Issue Specific Hearing 2

Thursday 1 December 2022

Supplementary Agenda Additional Questions

| C01 | For DCO Submission | | | | |

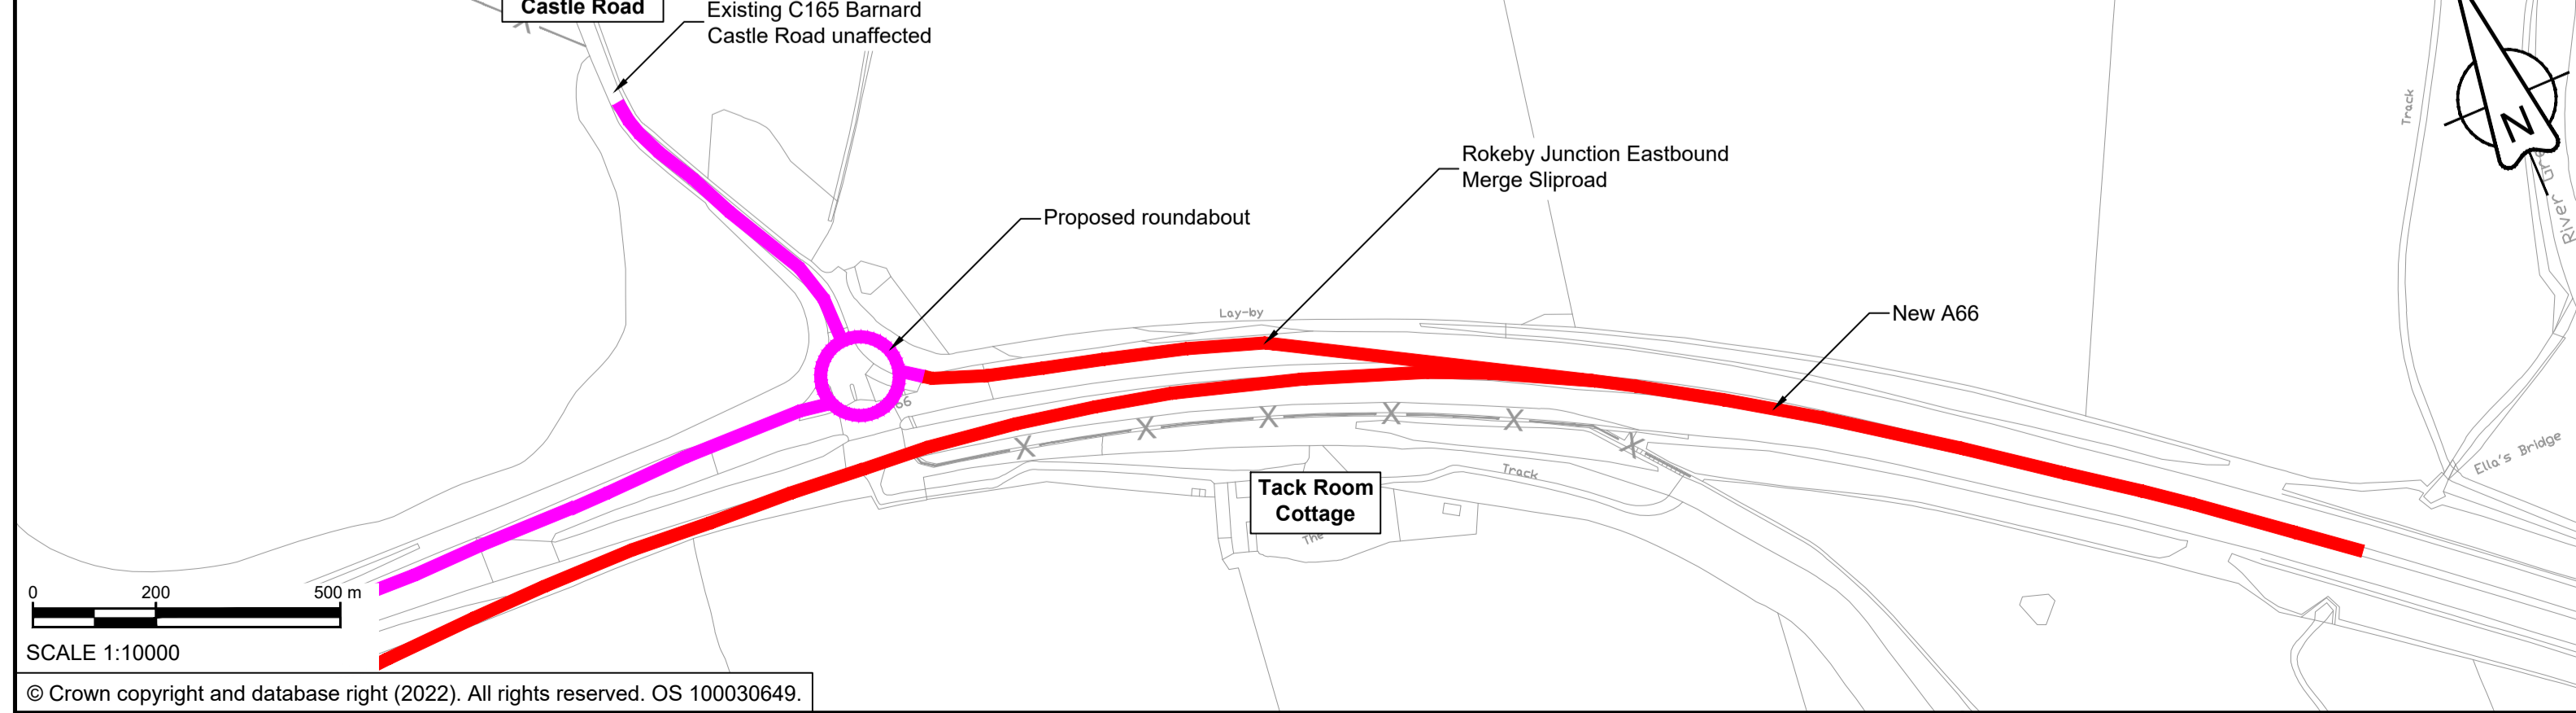
| ISH2.DCO.18 | Schedule 7 | Applicant | Paragraphs 55 and 56 both reference the new B1066. A and B classified road numbers are usually approved by DfT and are usually unique. There is already a B1066 (south of Bury St. Edmonds). Additionally, the use of a number starting B1... is unusual in road classification numbering to the west of the A1 which usually adopts the B6... sector convention. Confirm that this number been approved by DfT |

| ISH2.DCO.19 | | Applicant and Cumbria CC | Paragraph 56 (b) sets out that the B1066 ends at <i>“a point 254 metres west of the junction of Musgrave Lane and Main Street”</i> . Confirm that this is that a suitable point to start a classified road on the unclassified Main Street. Confirm whether it would be more conventional to connect the new B1066 to the existing B6276 on Main Street at its junction with New Road. |
| ISH2.DCO.20 | Schedule 8, Part 4, Revocations and Variations of Existing TROs | Applicant | There is an existing signed no entry restriction for westbound traffic on the extension of Main Street to prevent westbound traffic accessing the existing eastbound off slip of the A66. Confirm whether this would need to be revoked as this is intended to become a two-way B1066. |
